Consultation Response from KC, Trees	
2026/92410 George Hotel, St George's Square, Huddersfield, HD1 1JA	
New electrical sub station building to serve the adjacent George Hotel redevelopment (within a Conservation Area)	
Date Responded:	5th October 2026
Responding Officer:	AR
Responding Ref:	Huddersfield City Centre Conservation Area

Drawing Title:	AIS Plan
Drawing No:	RSH/AIS/01

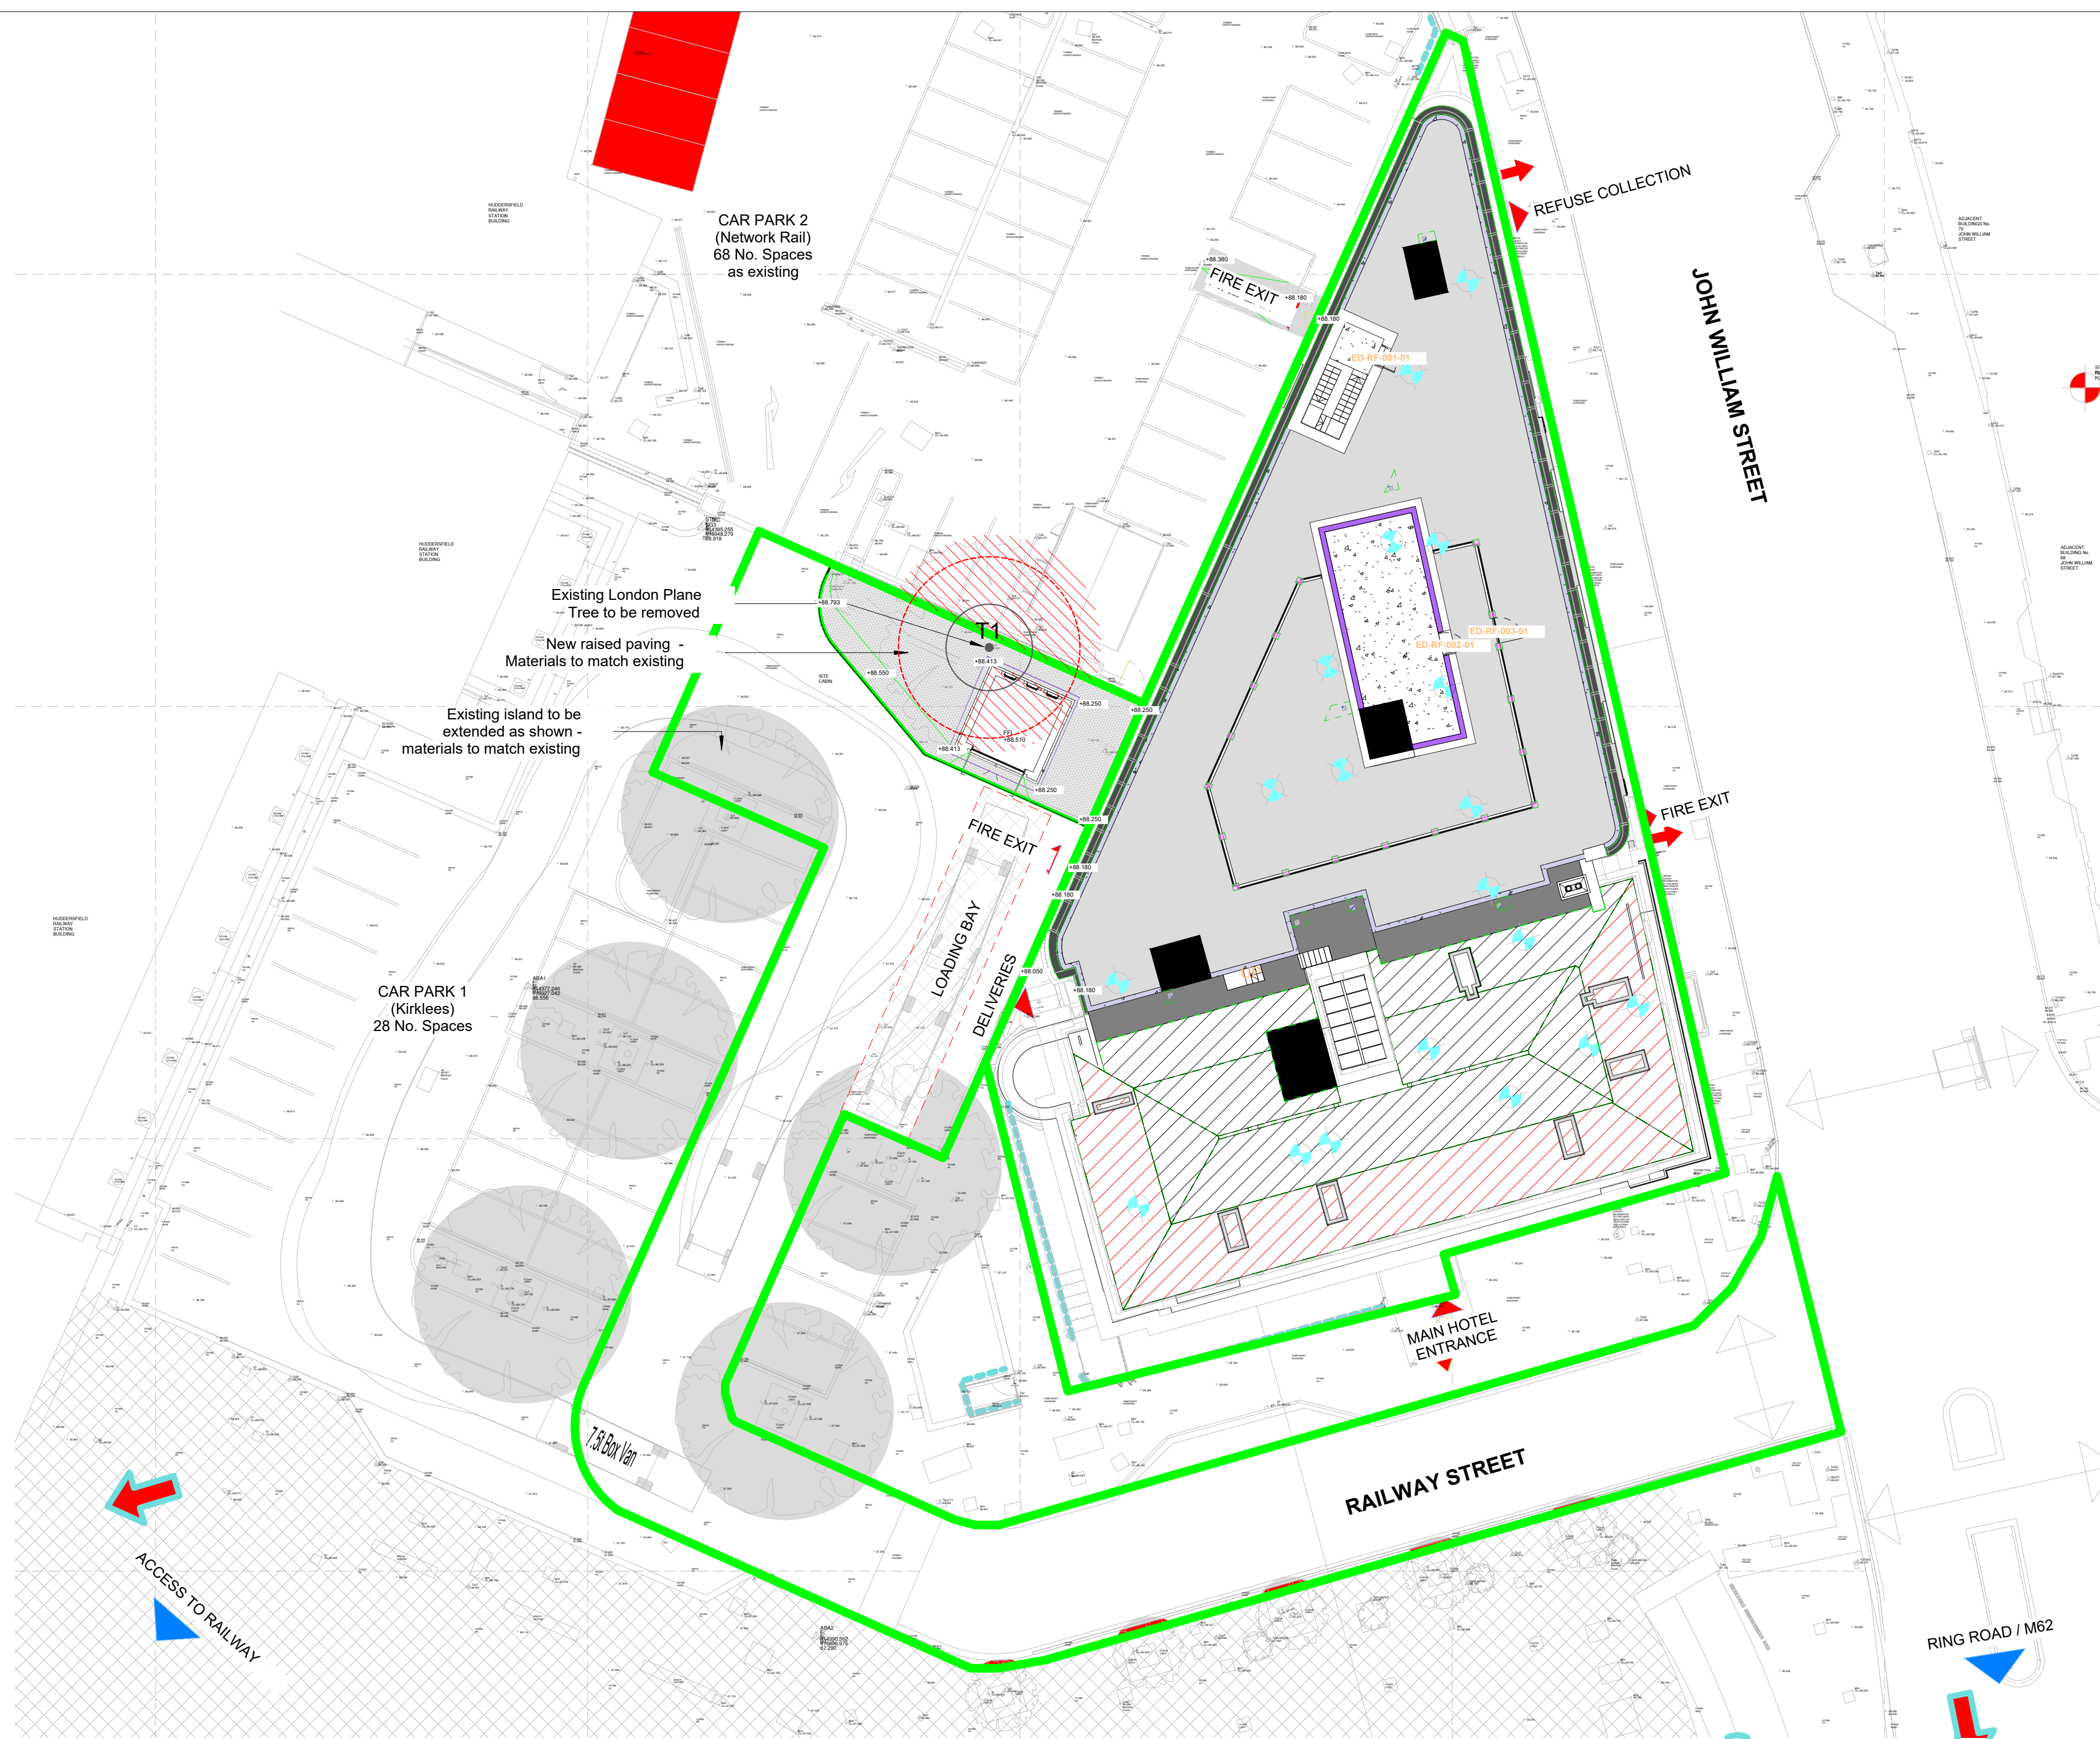
Whilst only a single tree is proposed for removal, it should not be considered in isolation. The tree forms part of a deliberately planned group of trees planted to support the restoration and enhancement of the conservation area. It also contributes to screening views from St George's Square towards the former goods yard, now operating as a car park. These trees are intended to become established and be managed in their current locations as part of the wider landscape strategy.

The loss of this tree would erode that screening function, open up views towards the car park and reduce the green infrastructure that has been established through recent townscape improvements. Consequently, the proposal would have a negative impact on the visual amenity and landscape character of the site.

The tree section considers that the removal of the tree has not been adequately justified. The applicant should demonstrate that reasonable alternative siting options for the proposed substation have been fully explored, for example, renovating the existing sub station. As the tree is planted within a root management system and is intended to form part of the long-term landscape framework, it is not immediately apparent that its removal is unavoidable. We would therefore encourage the applicant to explore design amendments that would allow retention of the tree whilst still delivering the required infrastructure.
